Application No: AB/55/20/PL
Site Address: 5 The Old Slipway River Road Arundel BN18 9EY
Description of works: New second floor Juliet balcony. This application may affect the character & appearance of the Arundel Conservation Area.

Thank you for your internet representation made on 29th June 2020 which has been recorded as no objection with the comments as follows:

**Second Floor Plan + Elevations**  
*as Proposed*

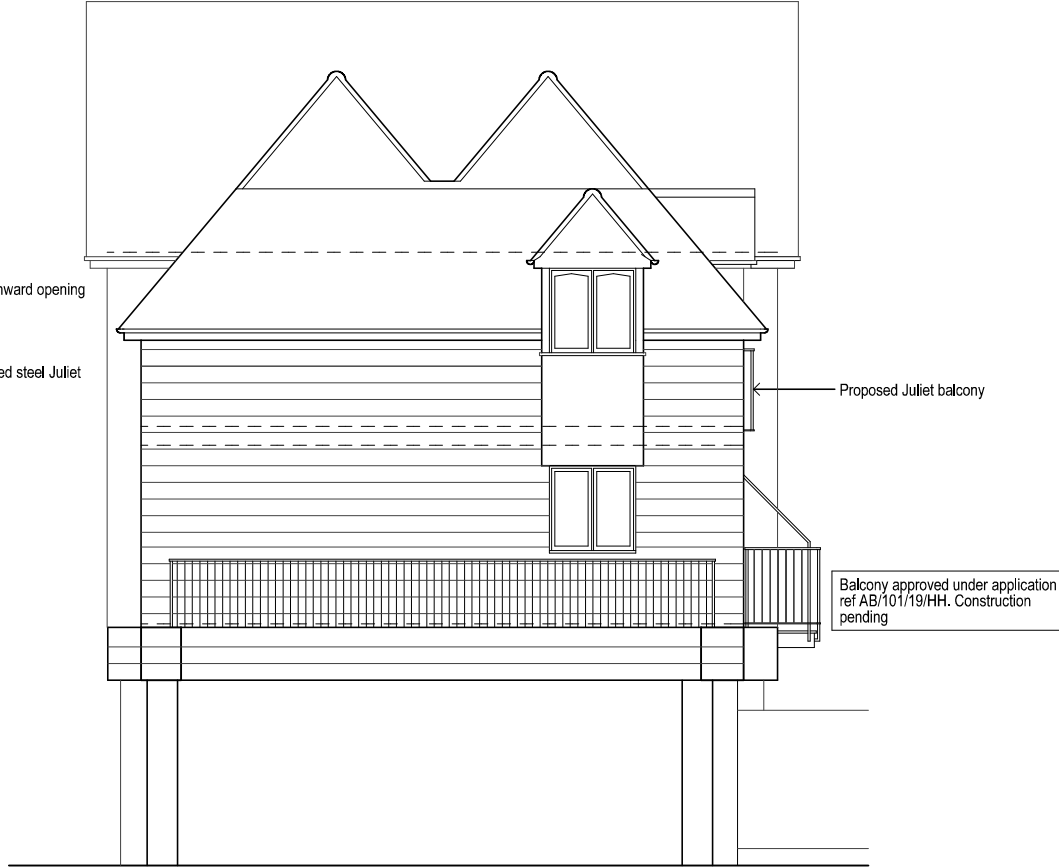
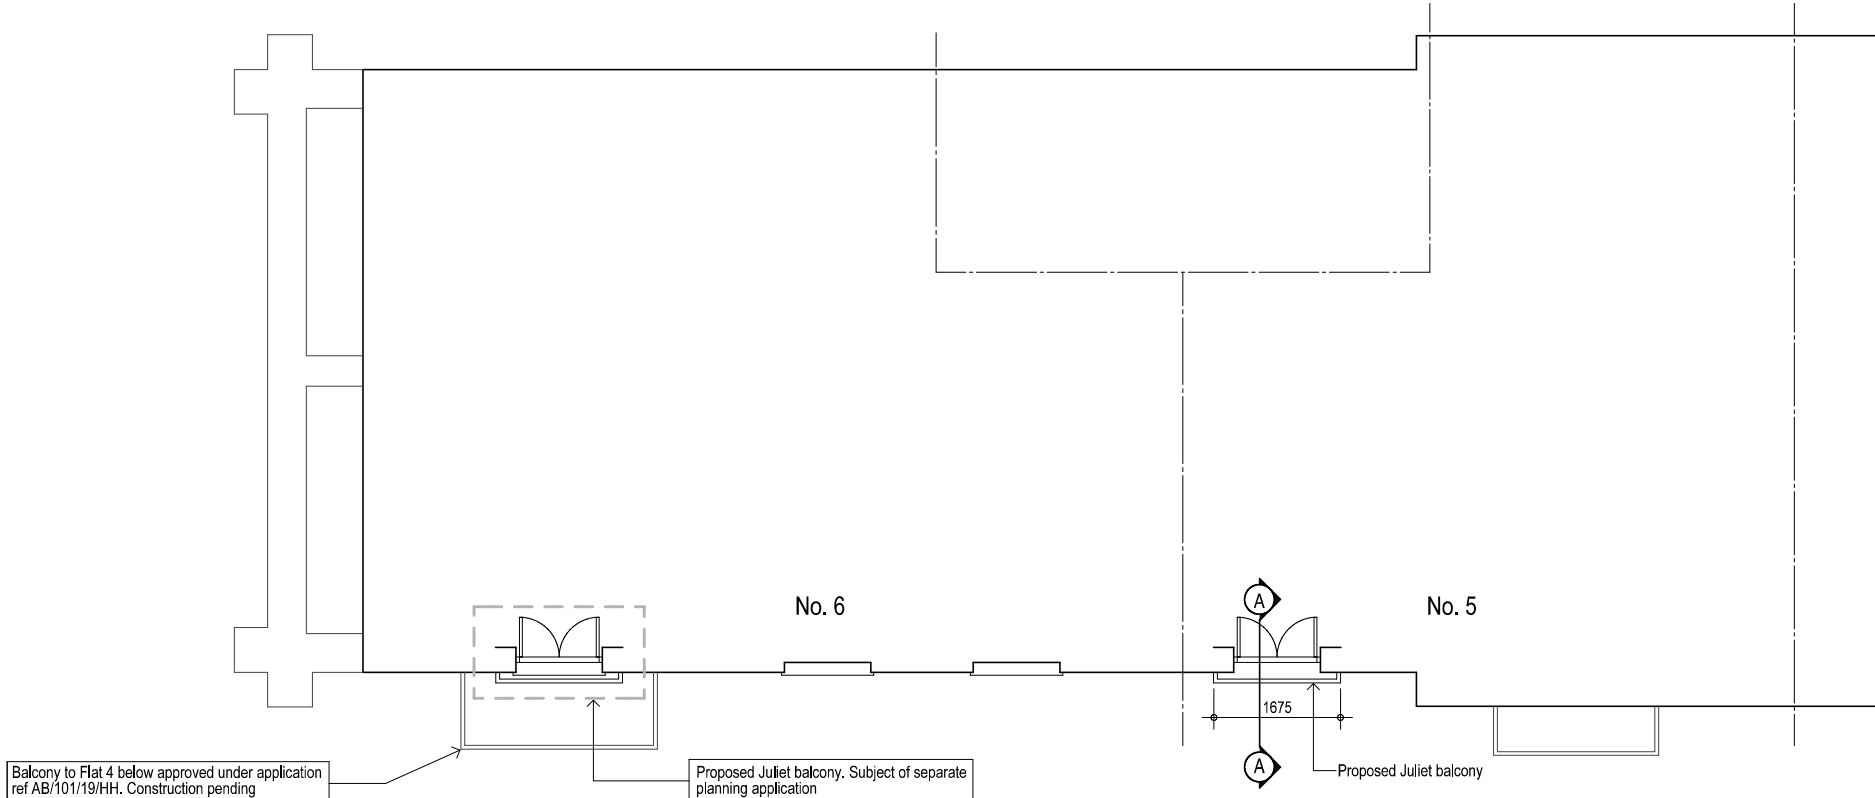
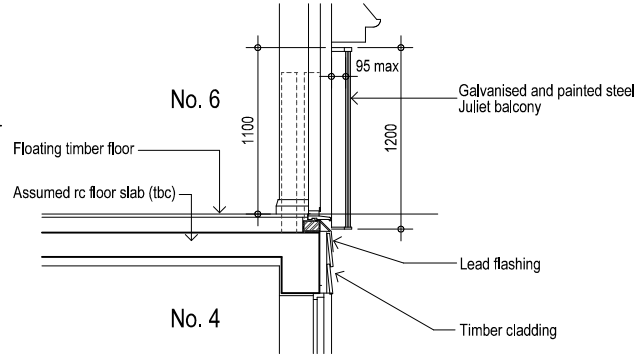
The scale, materials, proportions and sizes of these proposed balconies are sympathetic with those of the host building. The installation of these appropriately sized and proportioned structures provides visual interest on the river elevation.

It is suggested that a condition be attached to any planning permission requiring details of the colour of the paintwork for the balconies since it will be important to ensure a consistent colour scheme for all these new structures on the river elevation of the building. The new french doors also need to match existing ones in external appearance, including colour.
